**Wallarah 2 Coal Mine – Amendment to Development Application SSD-4974 (the amended DA)
lodged for the Wyong Areas Coal Joint Venture (WACJV) on 7 July 2016**

I refer to the above application and wish to lodge my objection to the proposal on the grounds detailed below:

Figure 3: Conceptual Project layout: Tooheys Road Site.

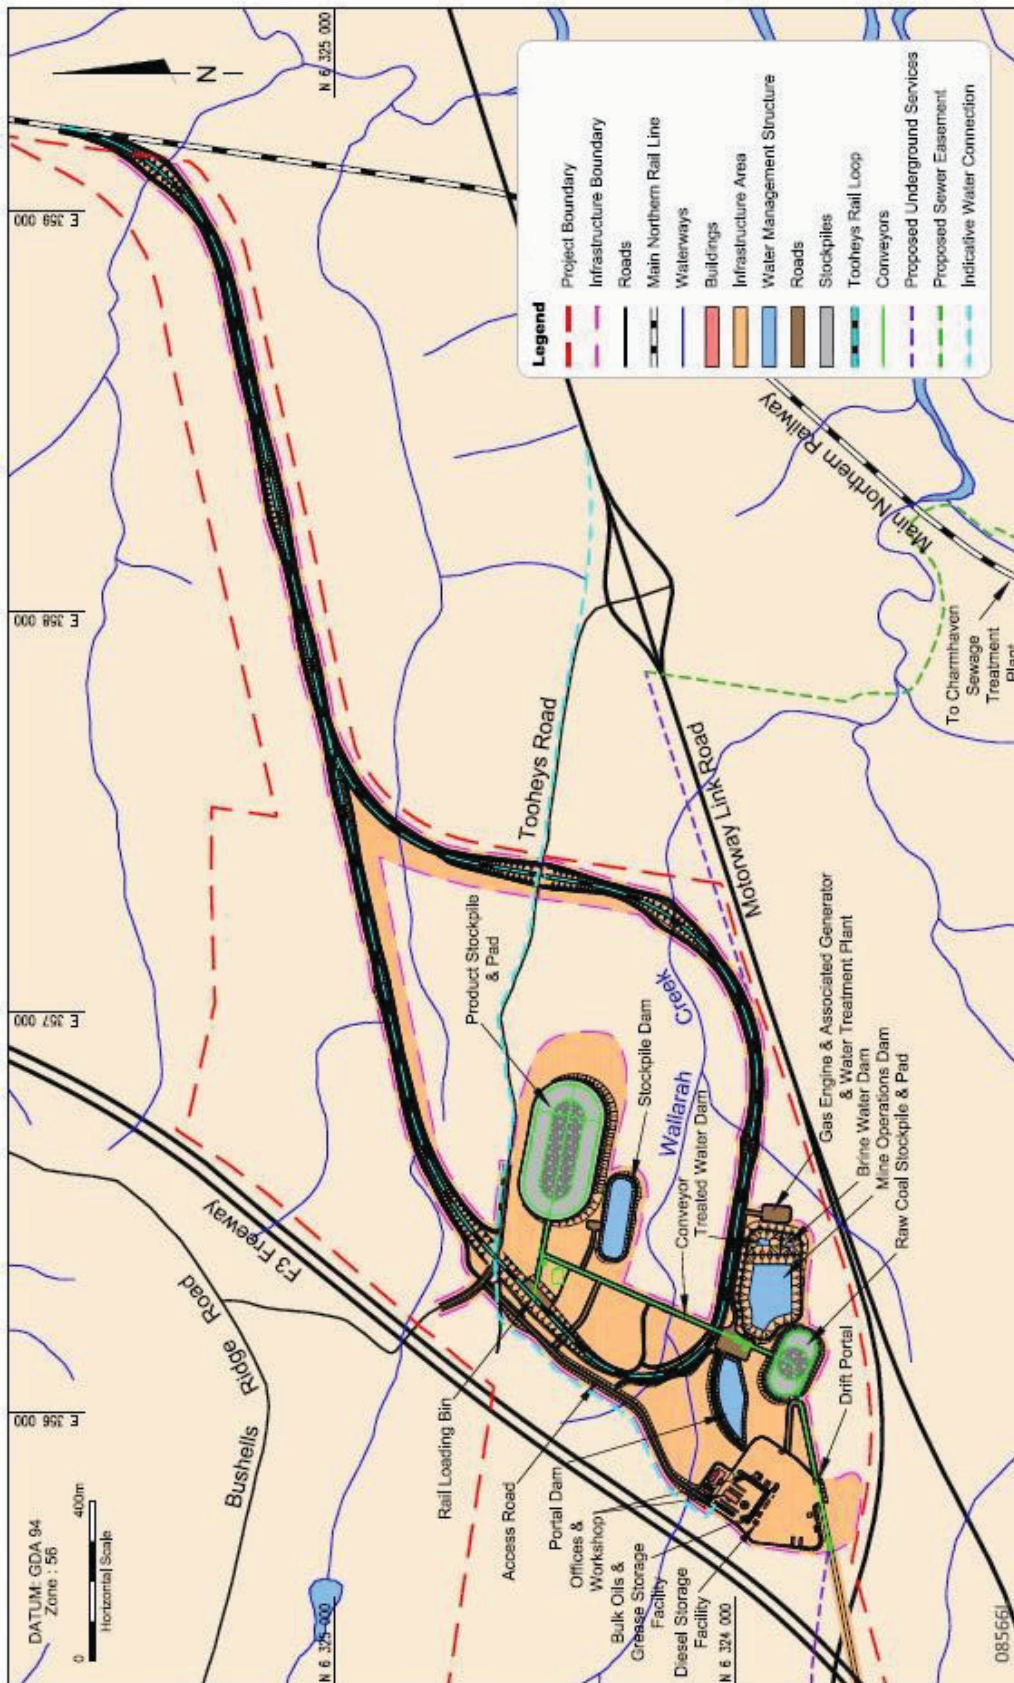
1. The infrastructure to be placed on Nikko Rd is adjacent to Spring Creek. The Amended DA does not address the risk of pollution to Spring Creek arising from the washing of coal, grease or oil into Spring Creek.
2. The Amended DA contains no detail on the location or design of water quality control devices presumably required within the Nikko Road, adjacent to the coal loading infrastructure, to ensure any stormwater or other run-off generated with the development (e.g. dust suppressant system) does not impact on nearby waterways.
